Application No: Y/5/26/PL
Site Address: 2 Downview Road Yapton BN18 0HS
Description of works: Erection of terrace of 4 No town houses with gardens and parking spaces. This application is in CIL Zone 2 and is CIL Liable as new dwellings.

Thank you for your internet representation made on 10th March 2026 which has been recorded as an objection with the comments as follows:

2 Downview Road, Yapton : Proposed 4-unit 3-storey Terrace of 3-bedroom Dwellinghouses : PROPOSED SITE LAYOUT

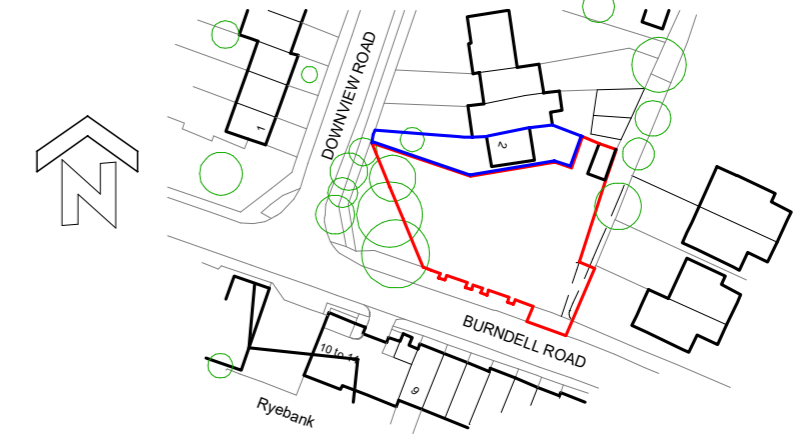
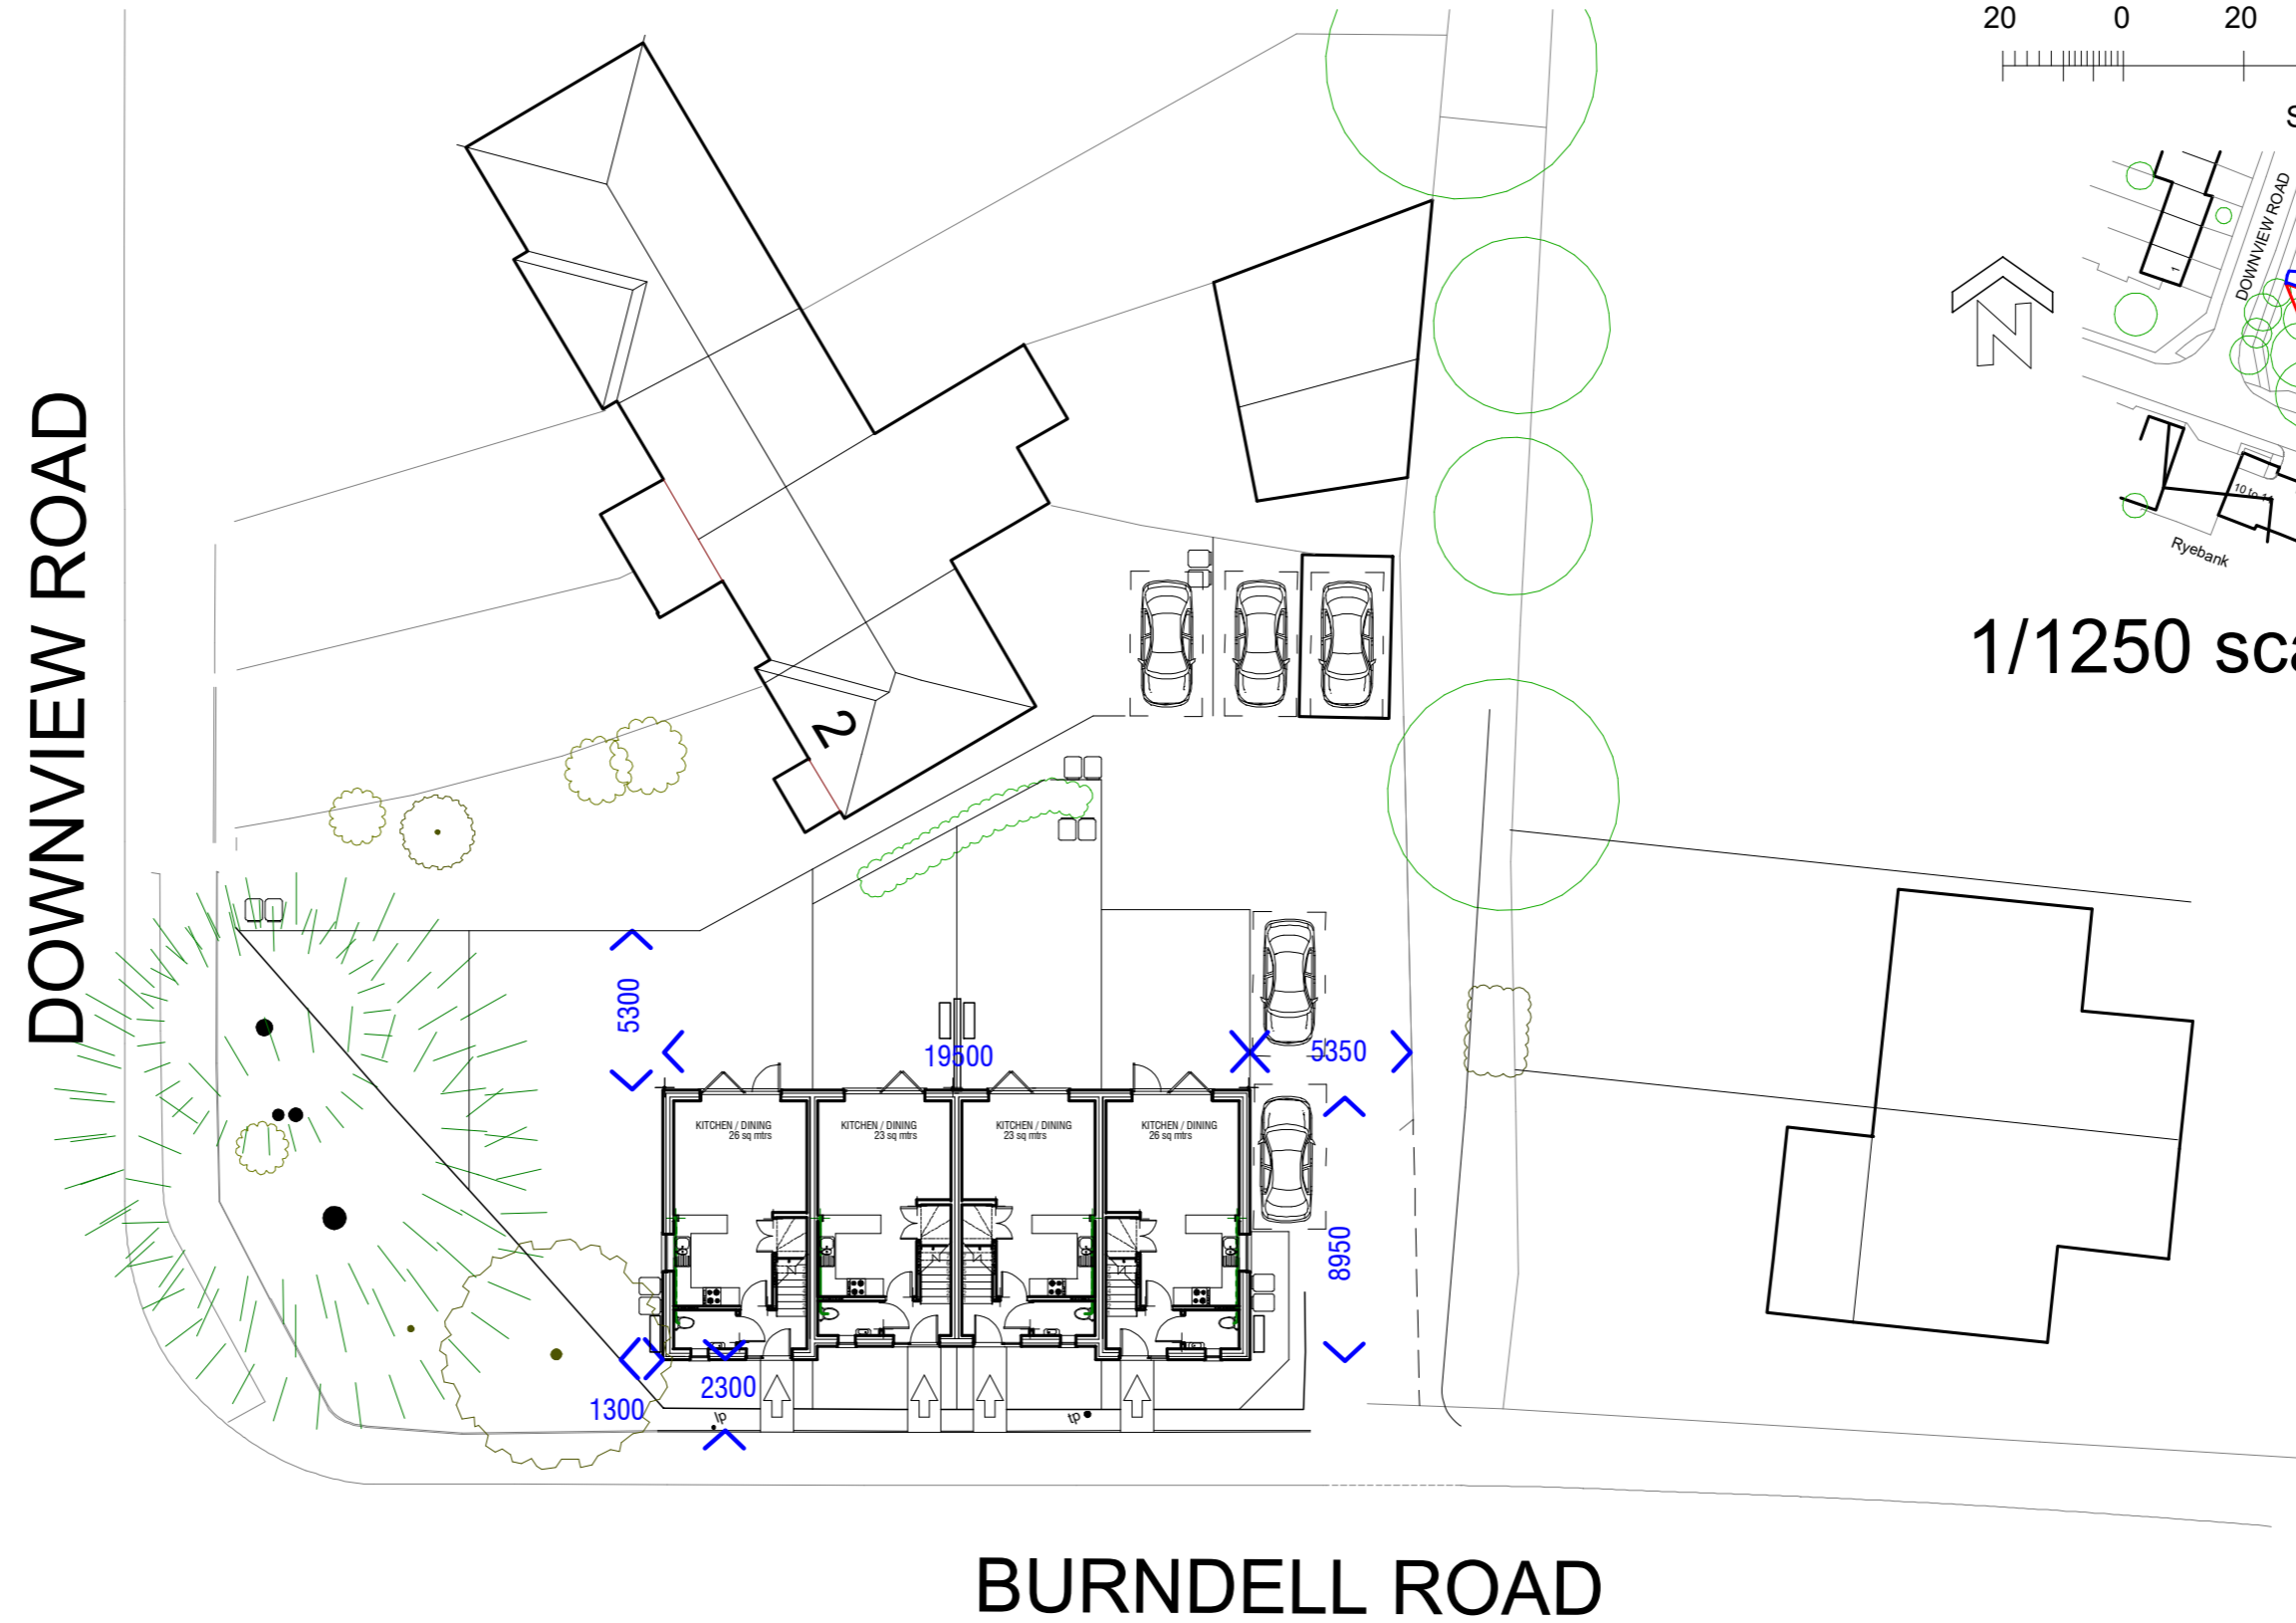
This would cause traffic problems as the cars would have to exit the properties onto the road right next to the existing junction. Due to all the recent building in Yapton Burndell Road is already a very busy, often congested road and to have more cars trying to exit onto it will cause more problems. We already have problems with parking in Downview Road, Close and Way and these houses would add to that. Although they are planning parking spaces most houses have at least 2 cars. In addition, we already have a lot of houses being built in Yapton which is resulting in no vacancies at the doctor's surgeries and the preschools.
